Re: Vista Del Norte, DRB 98-78

***RE: Grading and Drainage Certification Plan for Los Prados Del Norte Subdivision
(D16/D8) Submitted for Release of Financial Guarantees, Engineer's Certification
Stamp Dated 4/26/00.***

RE: *Drainage Report and Grading and Drainage Plan for Los Prados Del Norte Subdivision (D16/D8) Submitted for Preliminary Plat Approval and Grading Permit Approval, Engineer's Stamp Dated 3/5/99.*

TITLE: **LOS PRADOS DEL NORTE**
GRADING AND DRAINAGE PLAN

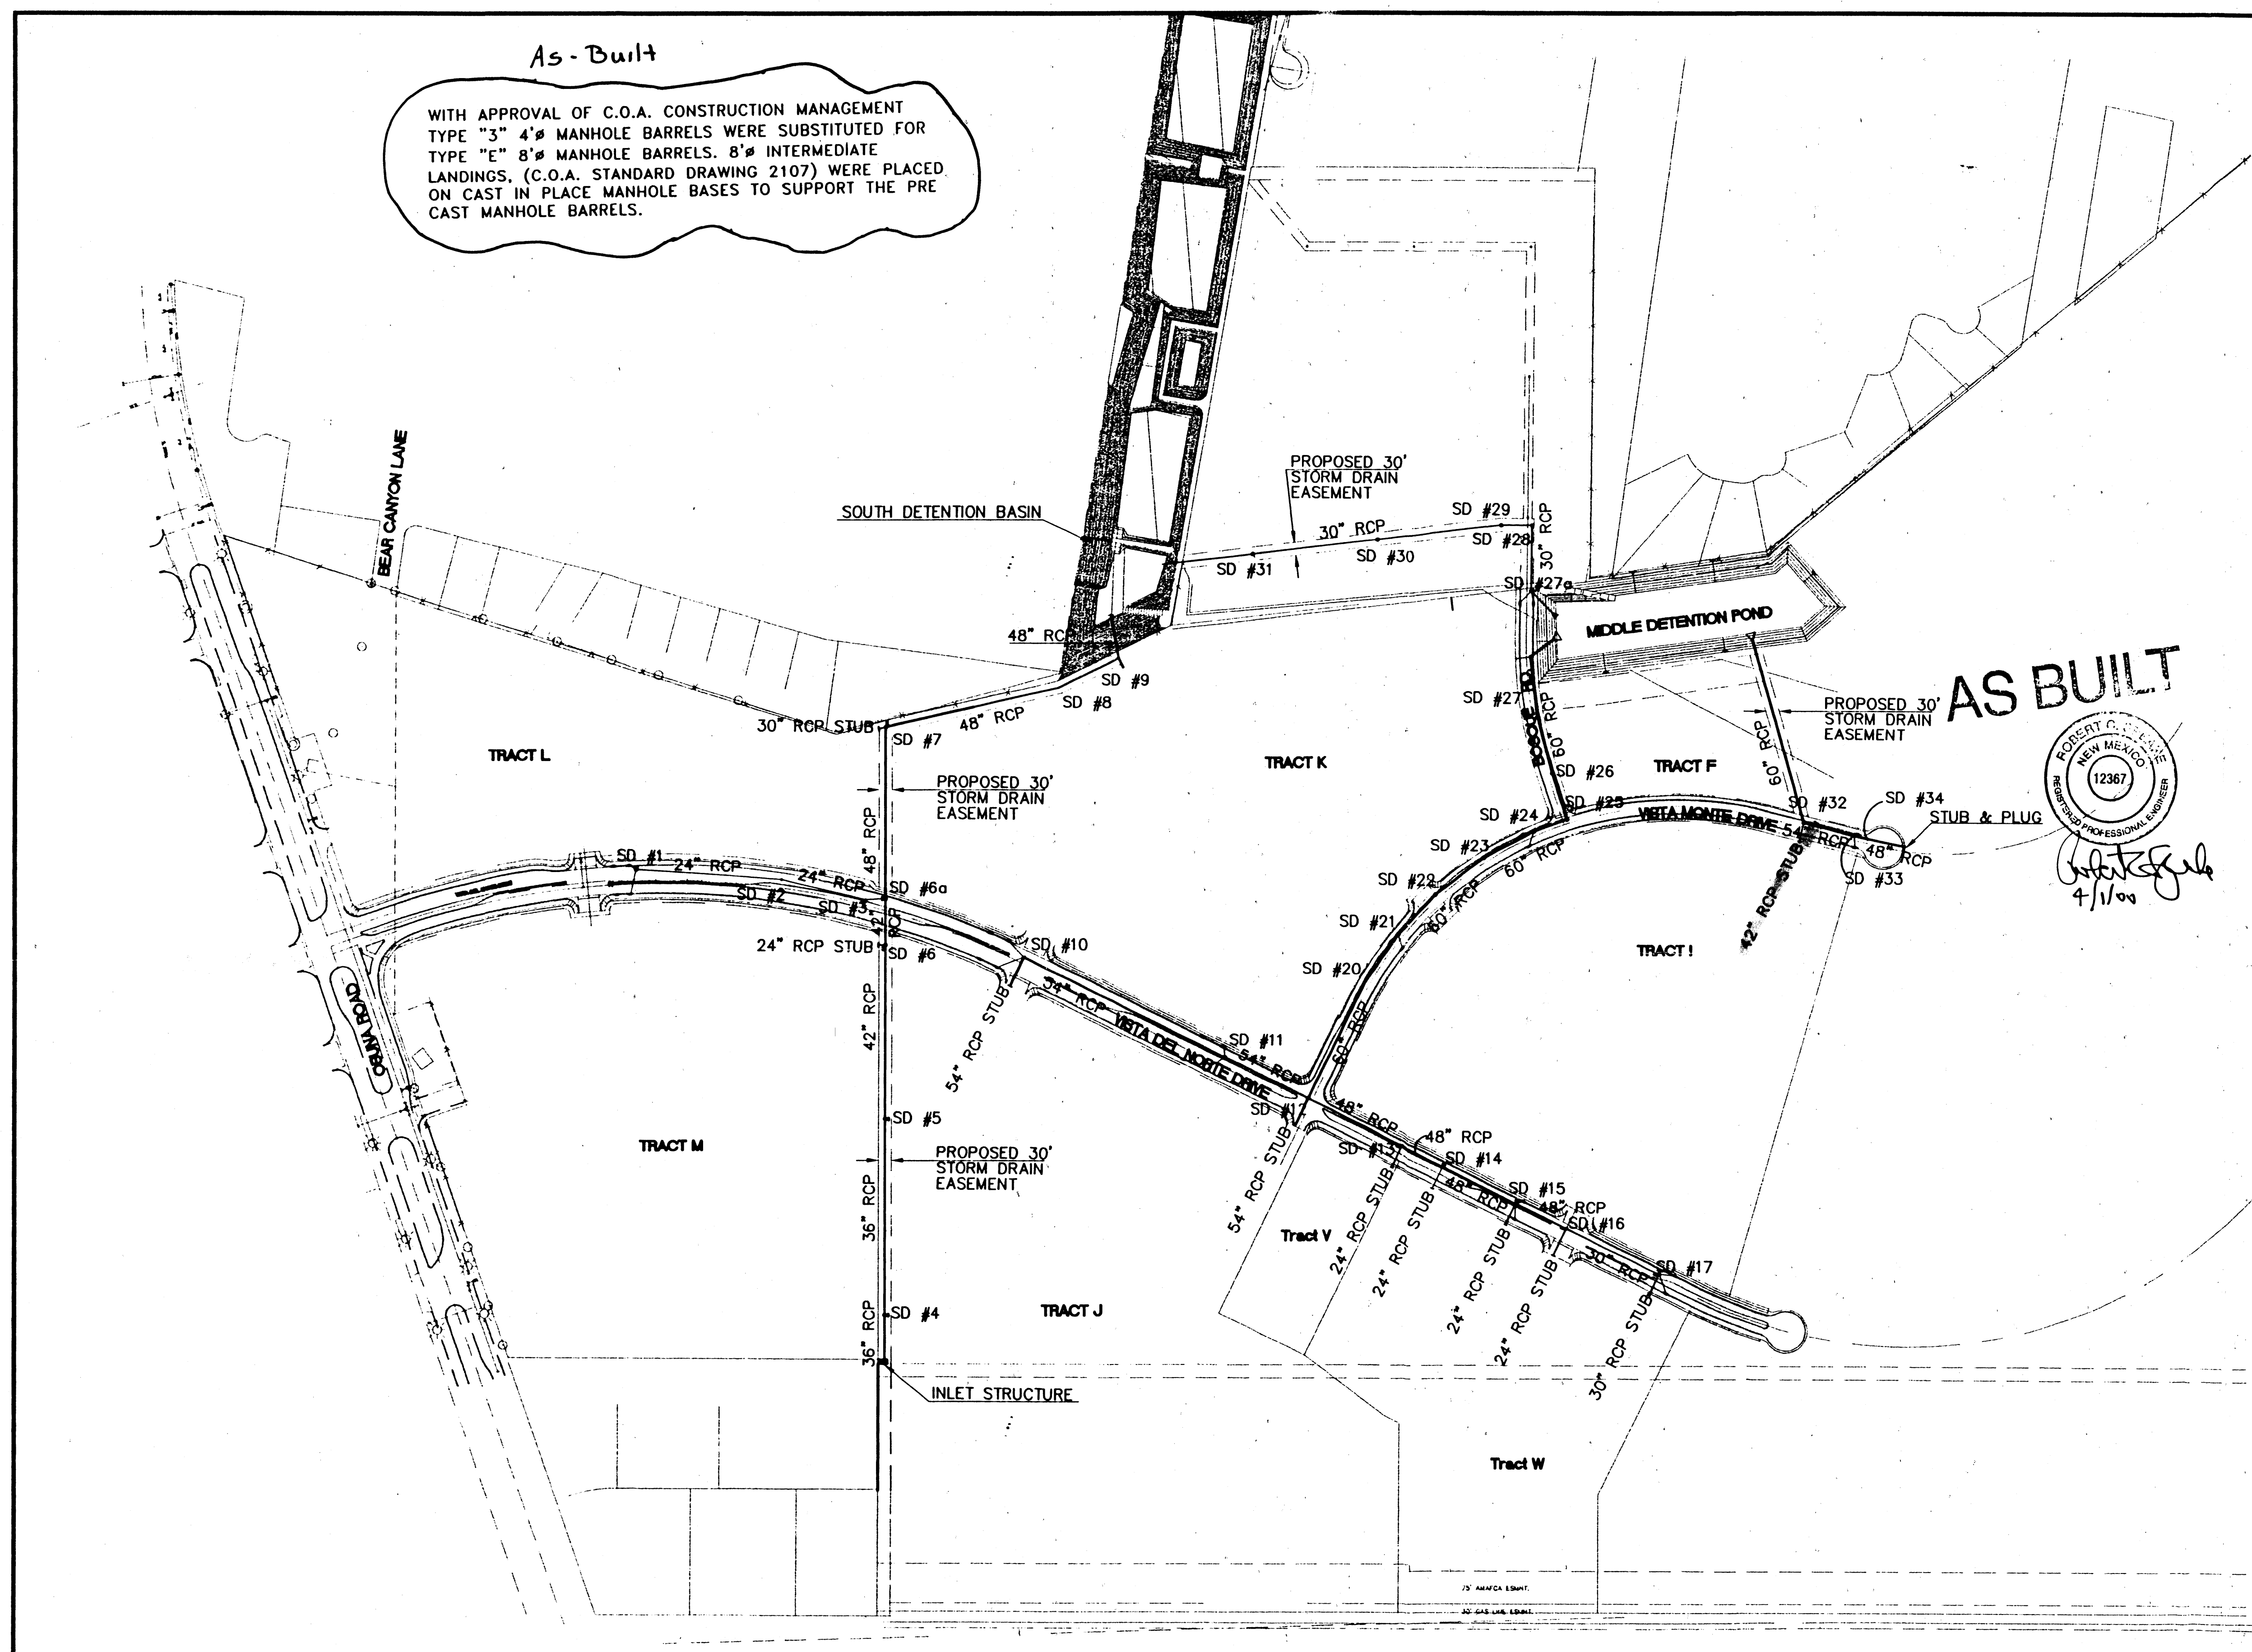
2. The master plan shows half of your site draining to the 60" storm drain on Vistu Monte Drive, then draining west on Bosque Drive, and the other half draining to the northwest corner of your site. Your plan shows the entire site draining to the northwest corner. Please demonstrate that the storm drains designed by the Vista Del Norte master plan can handle this change. Have the off-site storm drains been constructed?

4. With respect to the sump inlet calculations, please show the location of inlet # 4 on the storm drain layout (sheet 1 of 2). The grading plan must show that the proposed inlets don't conflict with the driveways.

City Project No. 5970.81	Zone Map No. D-16-Z & E-16-Z	Sheet 36a	Of 90
-----------------------------	---------------------------------	--------------	----------

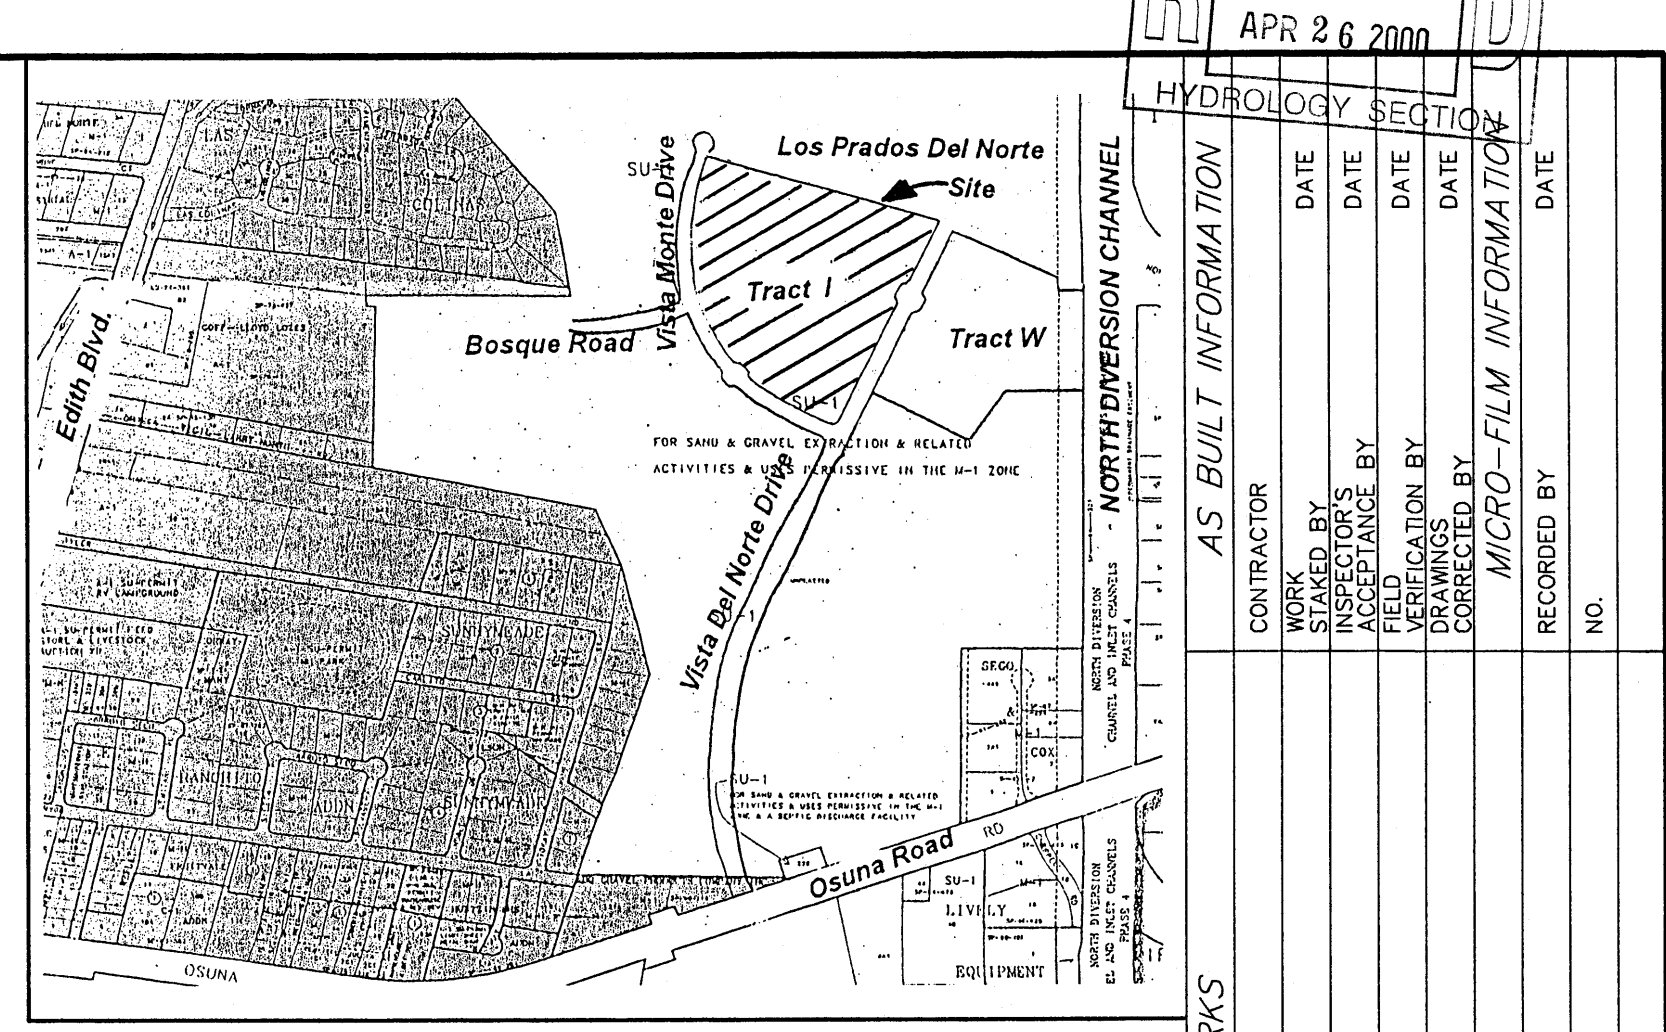
In Fred Aguirre's letter of May 10, 1999 to Diane Hoelzer, it was noted that some of the off-site storm drain pipes were to be upsized due to the development of the Los Prados Del Norte Subdivision. It is not clear whether a change order was ever processed to increase the sizes of the off-site storm drains in the vicinity of this site. Therefore, please provide the documentation to verify that these changes took place.

- Correspondence of 4/21/99 from Parsons indicating change to 42" would be required.
- Sheet 36a of construction drawings showing 42" stub-out to Los Prados. Please note that this sheet has been stamped and certified as "As-Built".
